PAUL MEW ASSOCIATES
TRAFFIC CONSULTANTS 020 8780 0426

CORNER OF FORE STREET AND HIGH ROAD

OBJECTION REBUTTAL

April 2023

1 Site layout
1 : 250

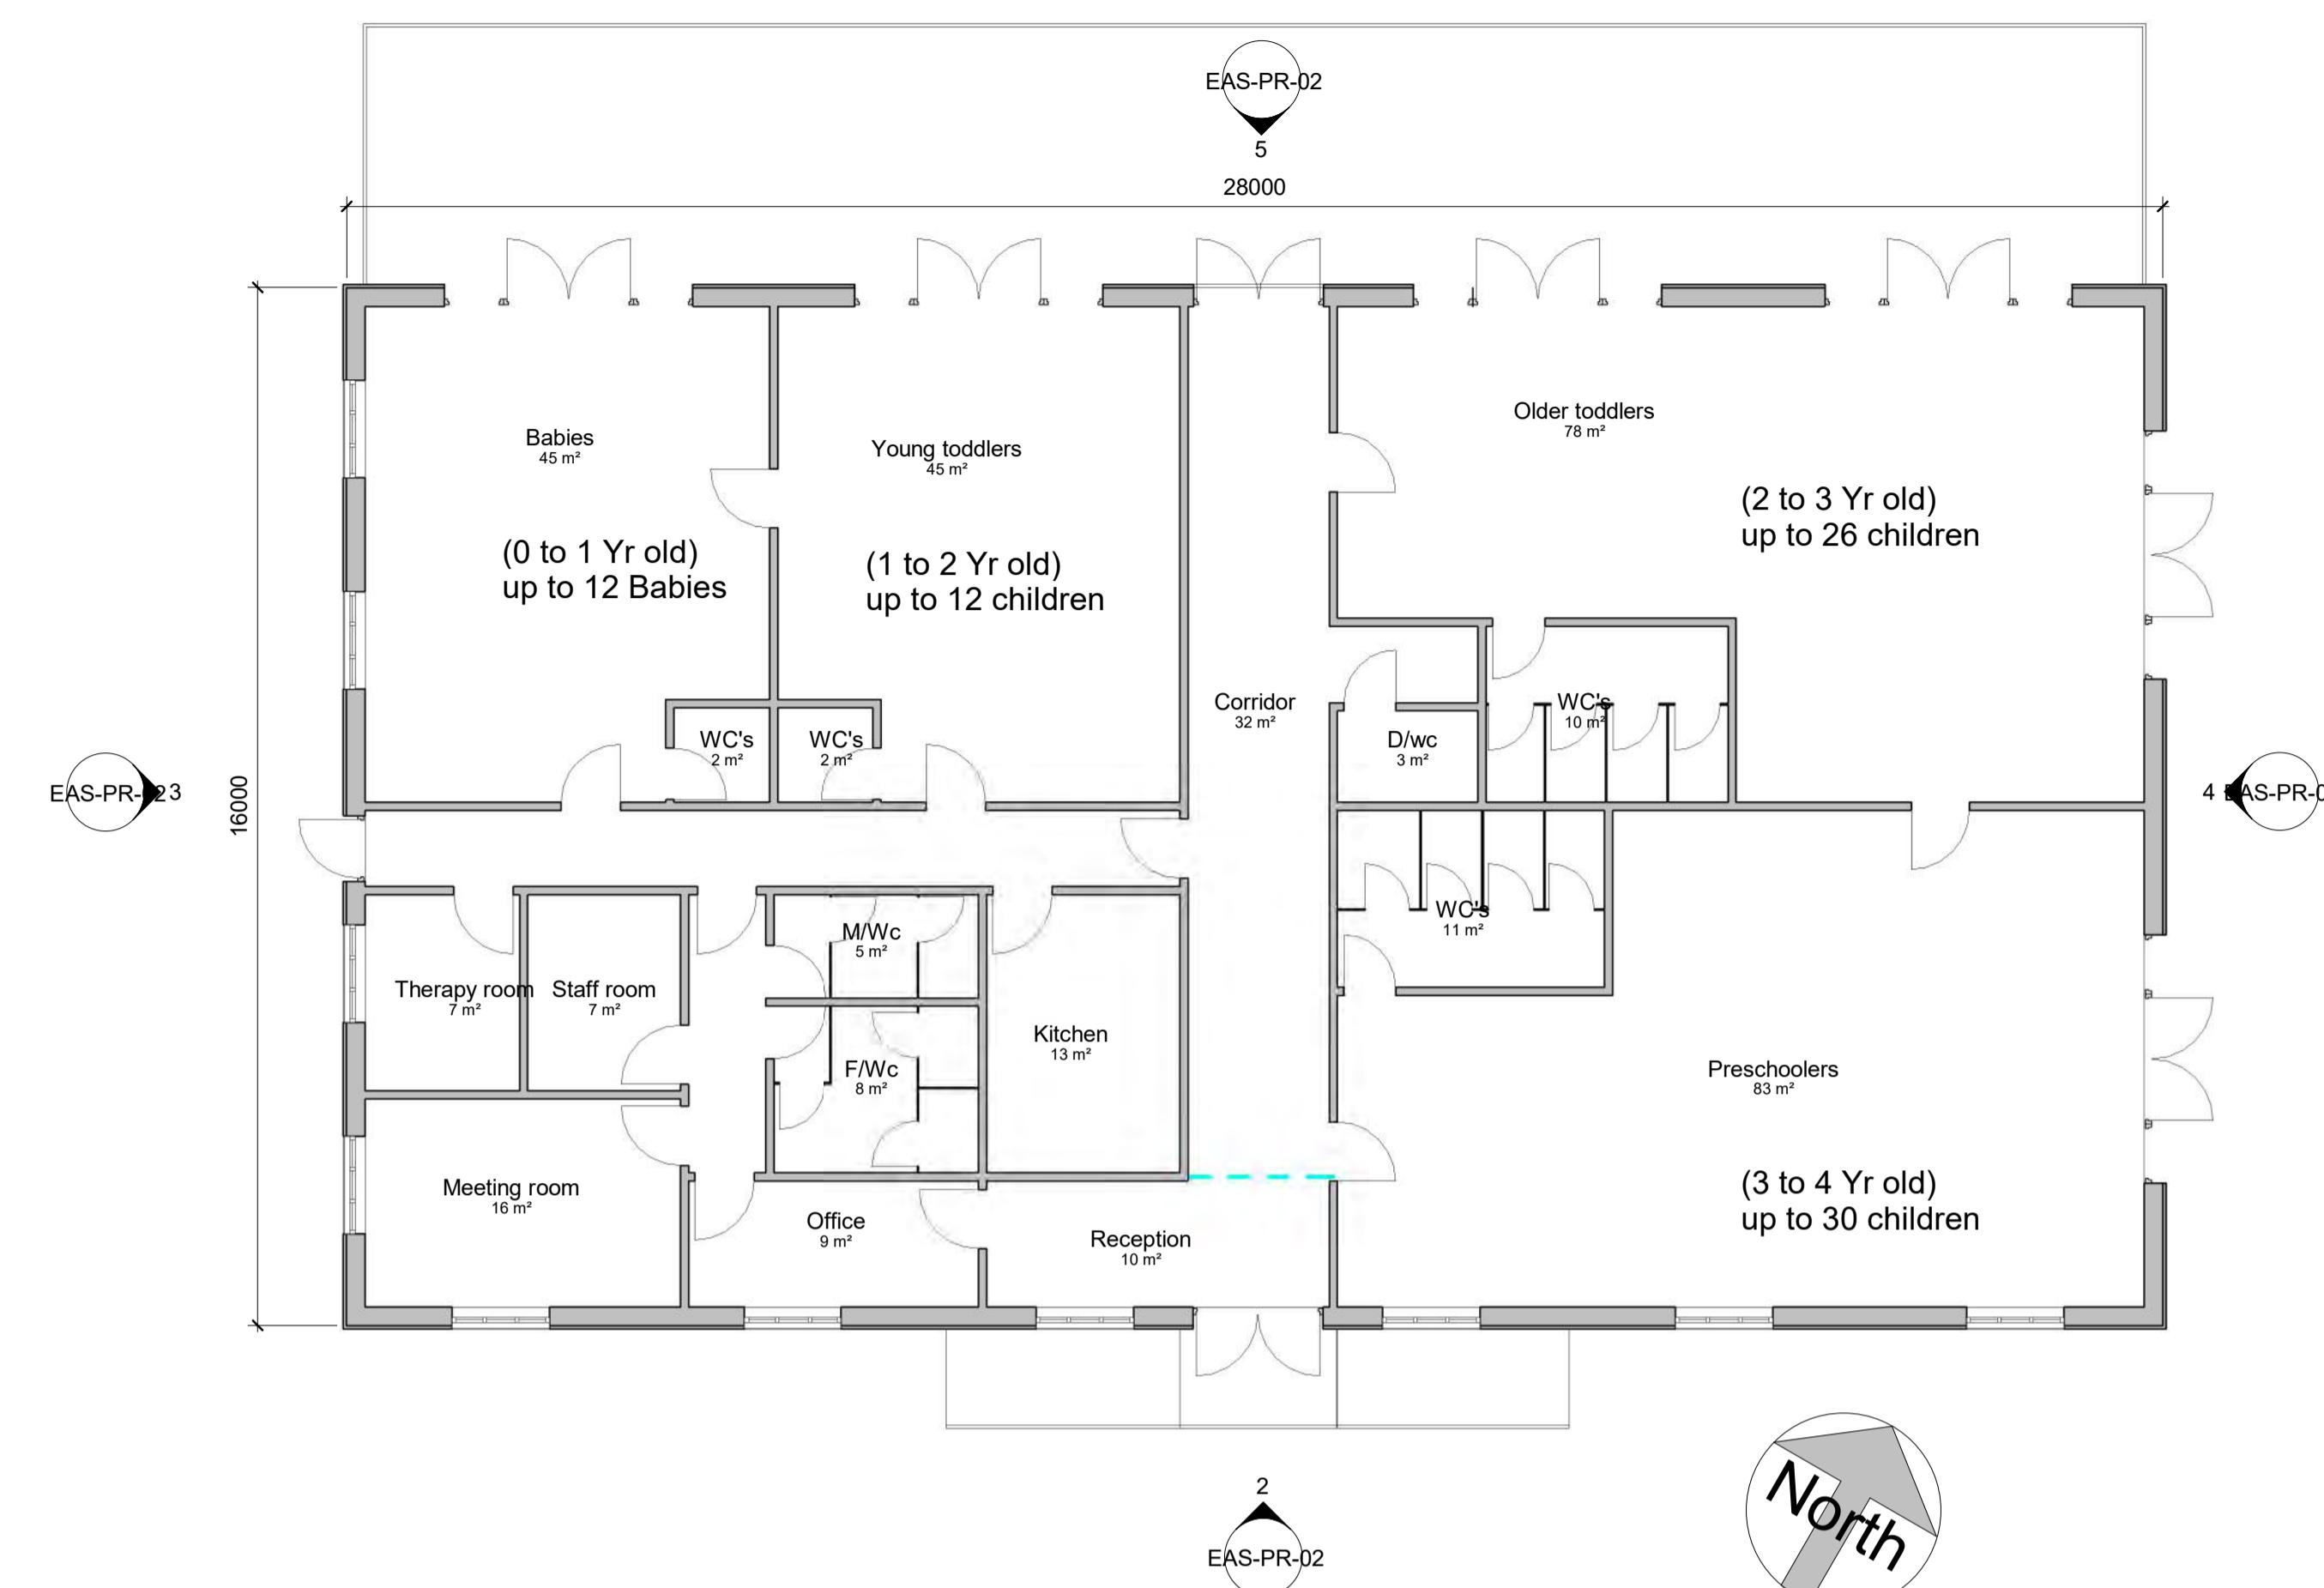
The site layout drawing shows the Bus stop with a (new) shelter recessed into the application site, which it would definitely need to be as the pavement there is very narrow – one or two people standing at the bus stop now, particularly with any buggies, block the way (the first photo in the attached photo document shows this situation). What is not shown in the application drawing is the fact that, along the stretch of the pavement between the bus stop and the corner of Fore Street, there is a lamp post, a telegraph pole for an overhead telephone cable and the street sign pointing to Spring Drive.

The proposed re-location of the bus stop is not adequate. The footpath, like the road is narrow. This path is used frequently by the residents of Grooms Drive, off Fore Street, to access the local shopping parade. Most of the residents require a motorised wheelchair.

The bus stop and the queueing area should all be situated off the footpath on the proposed nursery land.

2.25 As part of the proposals, a new walkway directly from the bus stop to the site is proposed. The proposals will also provide a setback bus stop, which will increase the available pedestrian width for those passing the stop. Please refer to the proposed plans. Improvements to the bus stop are proposed, which will benefit all.

- 2.27 The number of parking opportunities at peak times have been assessed as part of the submitted TS.
- 2.28 The proposed dropped kerb access is roughly in the same place as the existing dropped kerb, around 40 metres from the junction with High Road Eastcote. Detailed design will be confirmed at a later stage, however the safety of pedestrians, especially those with buggies will be prioritised.
- 2.29 As previously mentioned, the bus stop is proposed to be set back, allowing for additional width on the pavement.

- 2.31 The demand for parking on-street will not be high. Parking demand on-street has been assessed and as a worst case an additional three cars will need to park on local on-street unrestricted parking opportunities during the AM peak.
- 2.32 No changes to the road geometry are proposed.
- 2.33 As previously mentioned, the bus stop is proposed to be set back, allowing for additional width on the pavement. Refer to the proposed drawings.

P2776: Corner of Fore Street and High Road
 Figure 2
 Parking Survey Extent

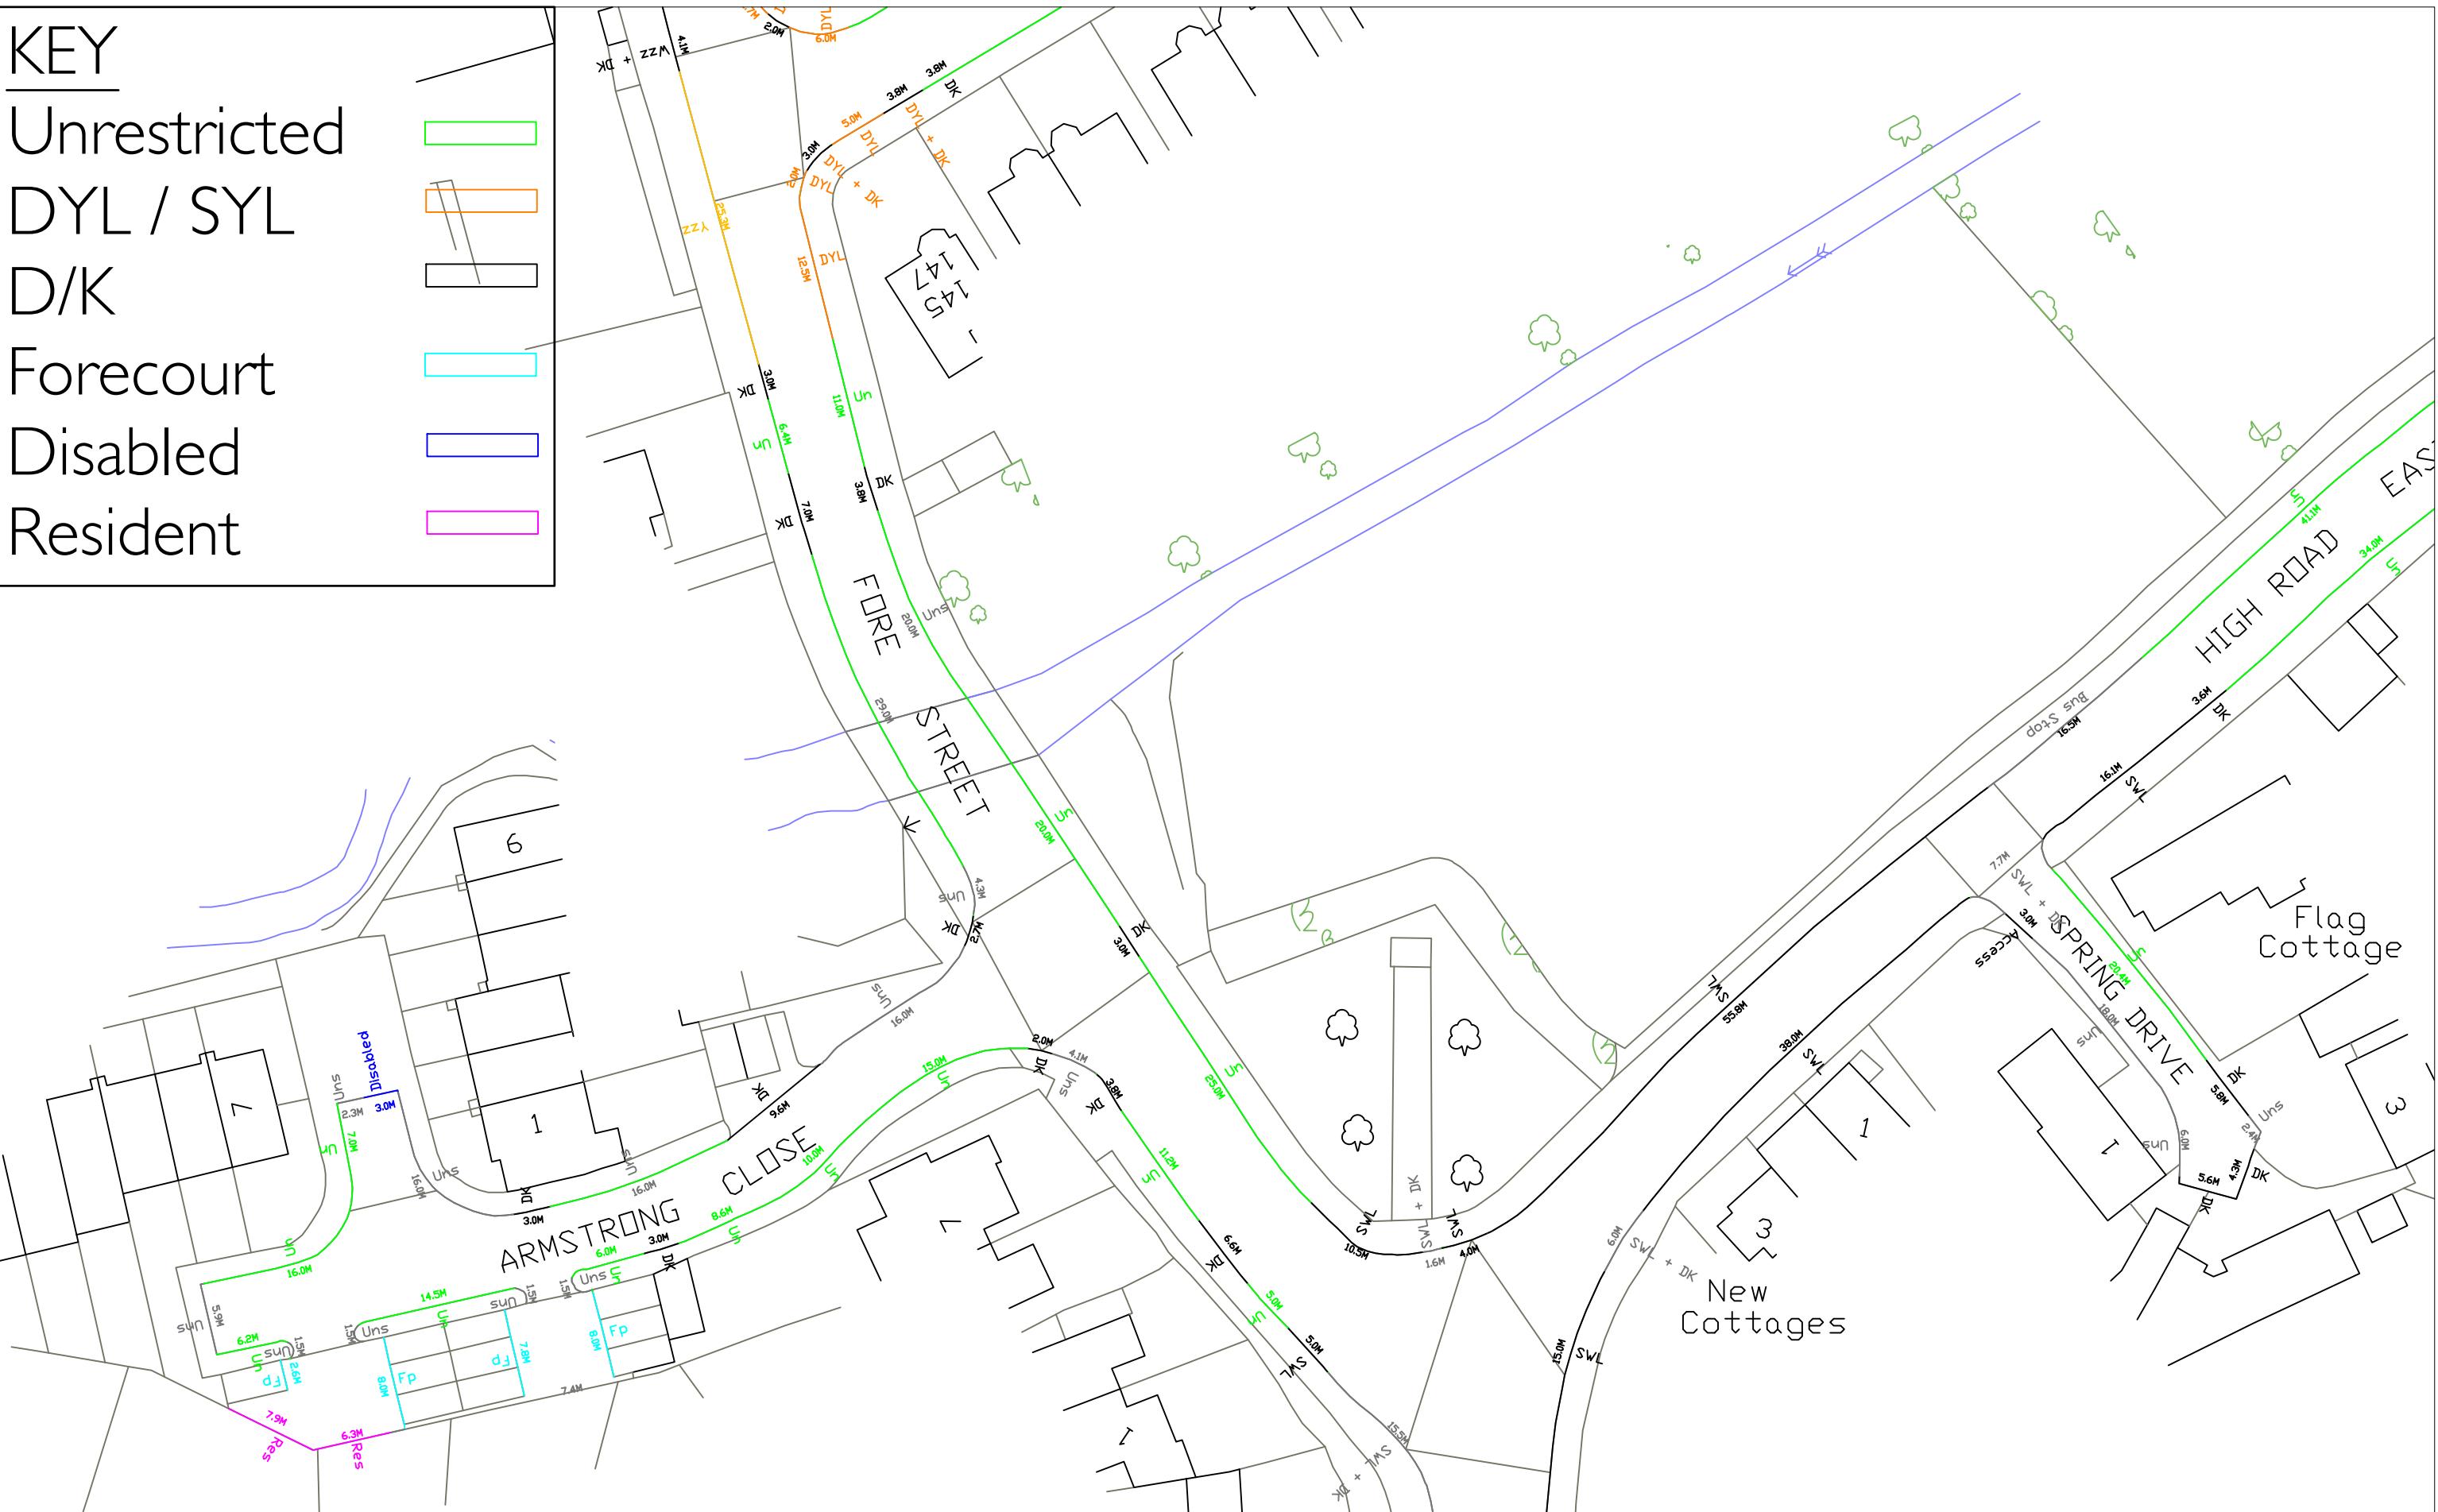
At peak times any available roadside parking spaces are already taken up. It cannot be agreed that the parking spaces given as available in the Transport Survey is correct. The map given within "Figures" towards the end of the Traffic Statement shows unrestricted spaces on the roadside from the Fore Street junction up to Armstrong Close.

There cannot be parking on that side of the road as well as Pretty Corner side due to restricting width of road and thus cars able to pass in both directions. No-one parks on that side, during peak times and indeed very rarely ever. There has to be free-flow ability for traffic turning into Fore Street from Eastcote Road /High Road Eastcote otherwise there will be further traffic hold-ups in the main road. The unrestricted parking spaces in Fore Street are shown right up to Wentworth Drive – a great distance from the nursery. Cannot imagine those dropping off will want to park at such a distance. If spaces are to be found there those dropping off for the existing 2 nurseries, Infants School, Junior School and Grangewood would take those up. There is the width restriction at the bridge in Fore Street just beyond the site so parking at the point is not possible.

2.20 Peak parking surveys have been undertaken which have indicated that all roadside parking opportunities are not already taken up. The surveys are undertaken in line with the Methodology. This includes a 200m walking distance from the site. The width restrictions on the bridge has been considered and is not included within the unrestricted parking count – it has been considered unsuitable.
